**SUBJECT: BRES2112-0031
BUILDING RESIDENTIAL**

Here are the results of all Inspections located at **60 AVERY RD:**

Foundation Plan

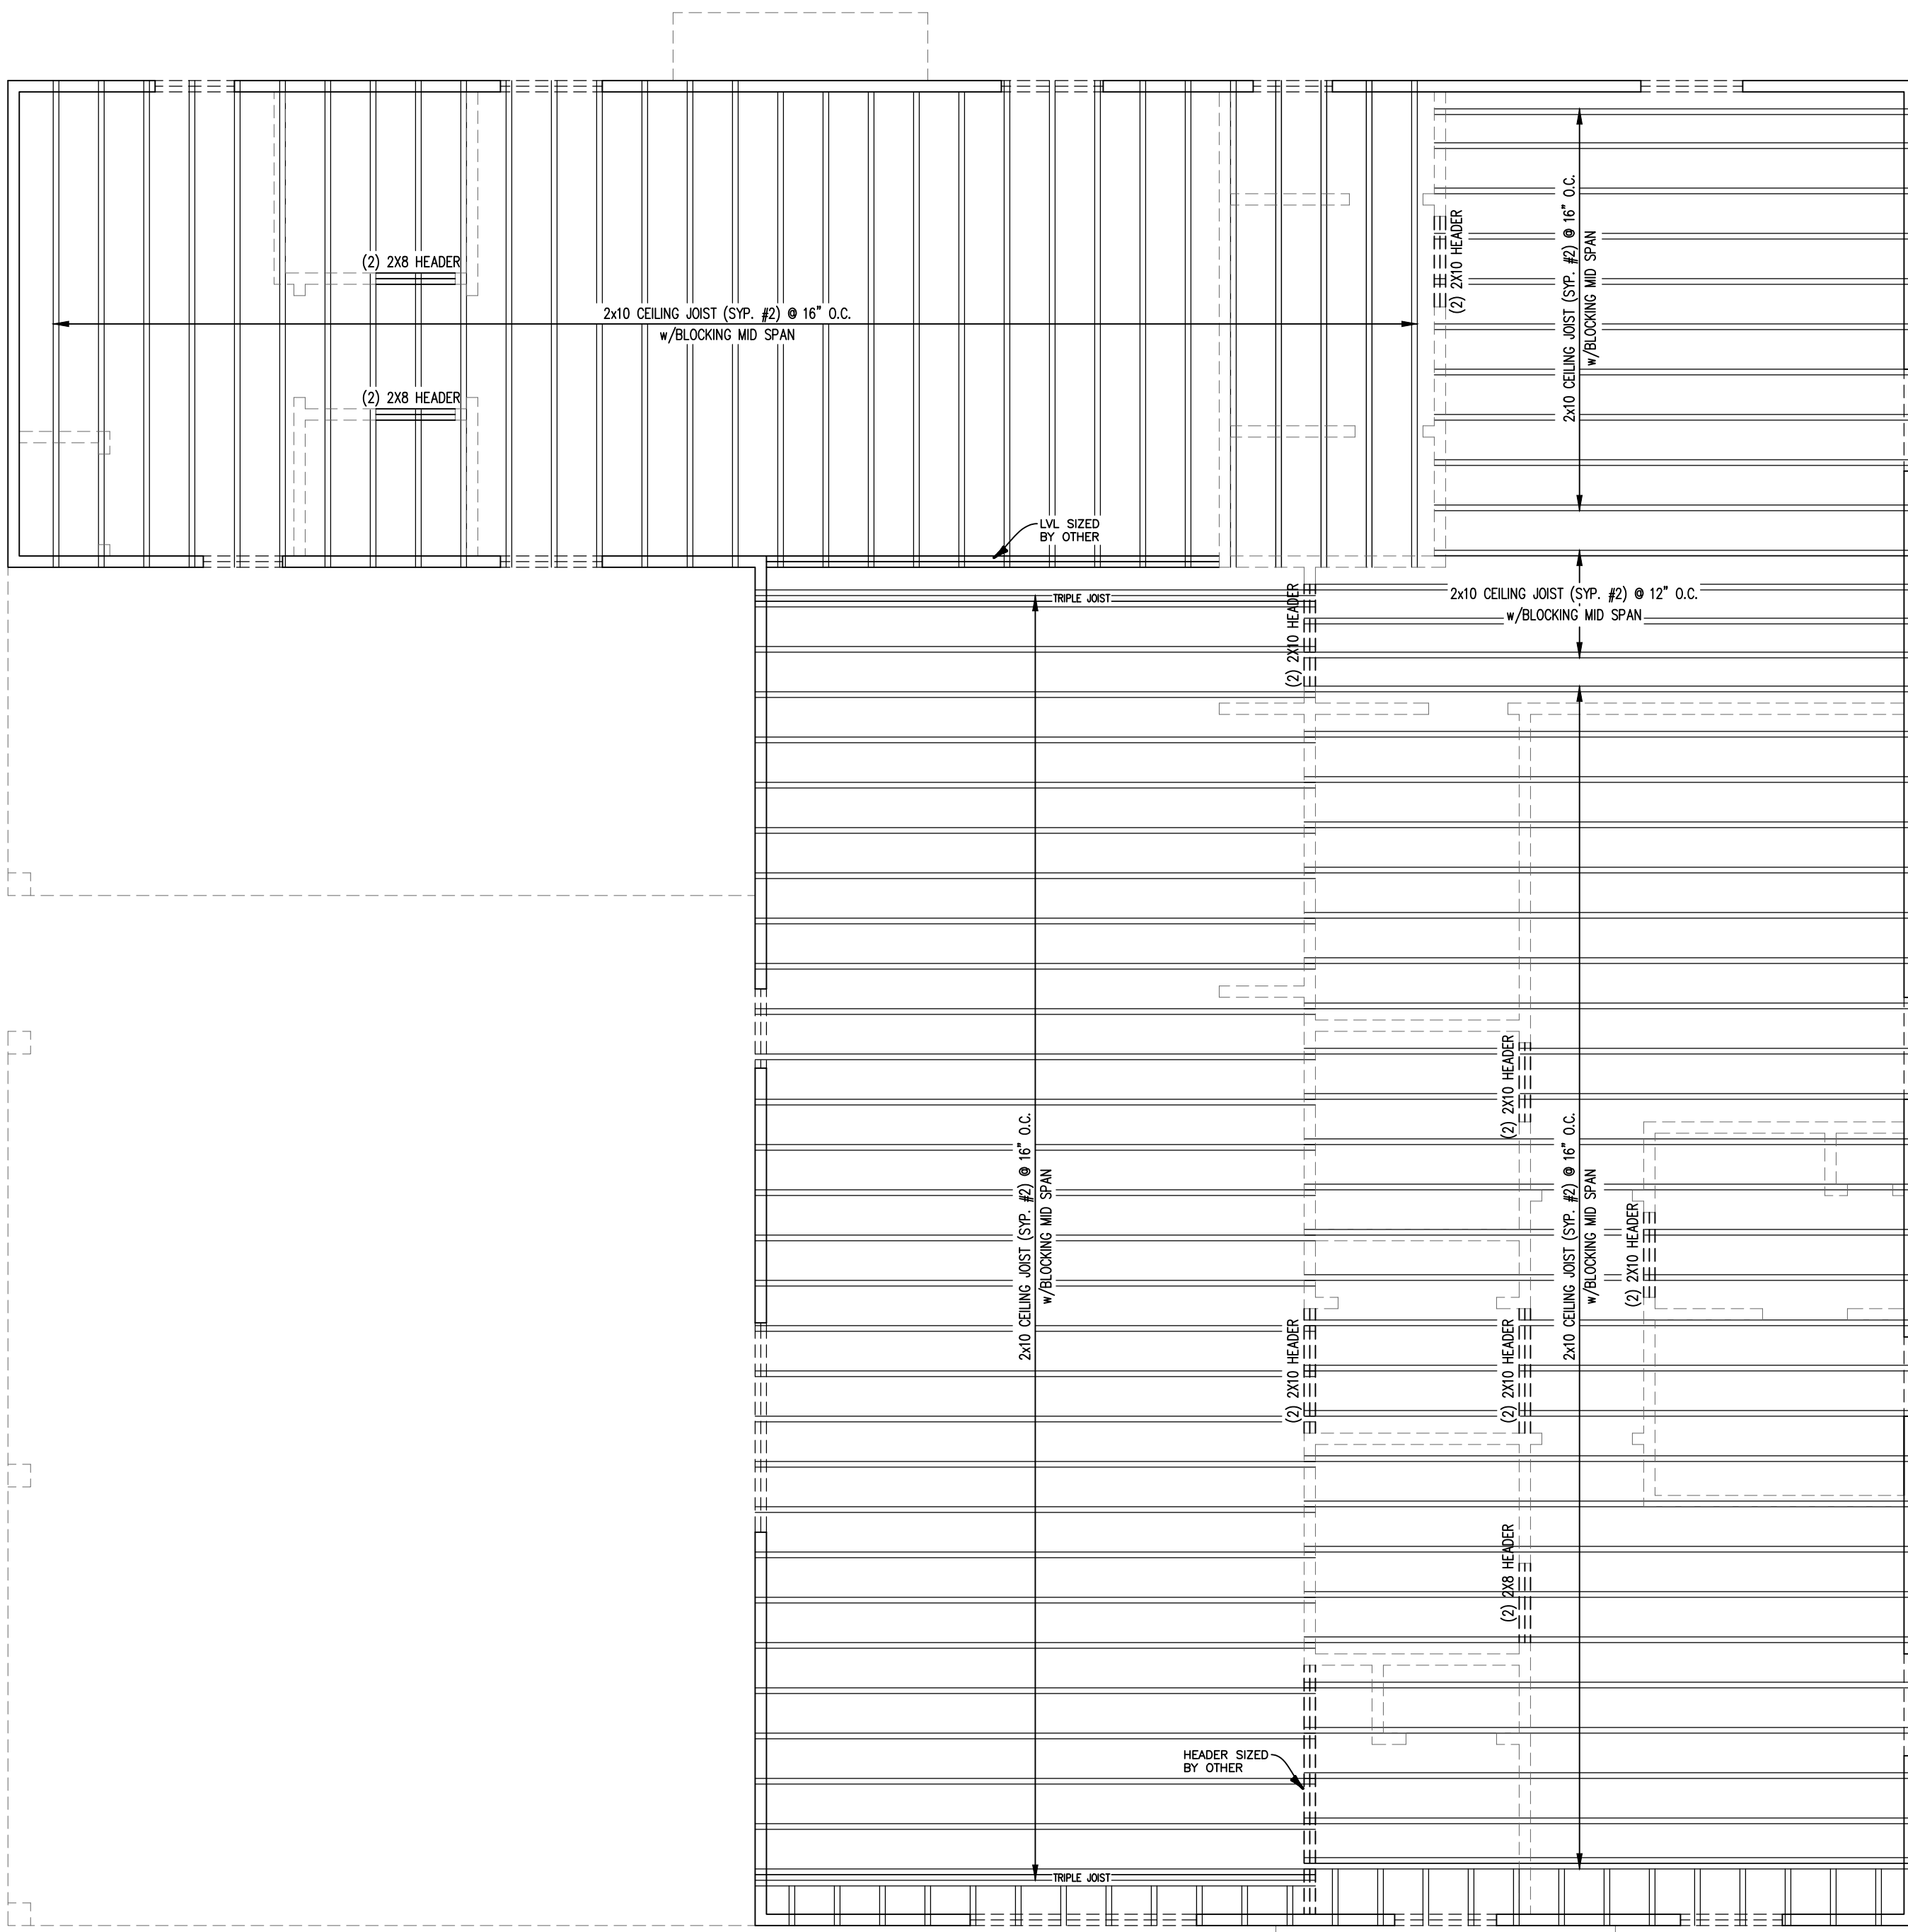
Inspector TSG changed the inspection assignment from TSG to JRM
2 piers per design missing at girder ends. Need engineer to provide letter if using hangers
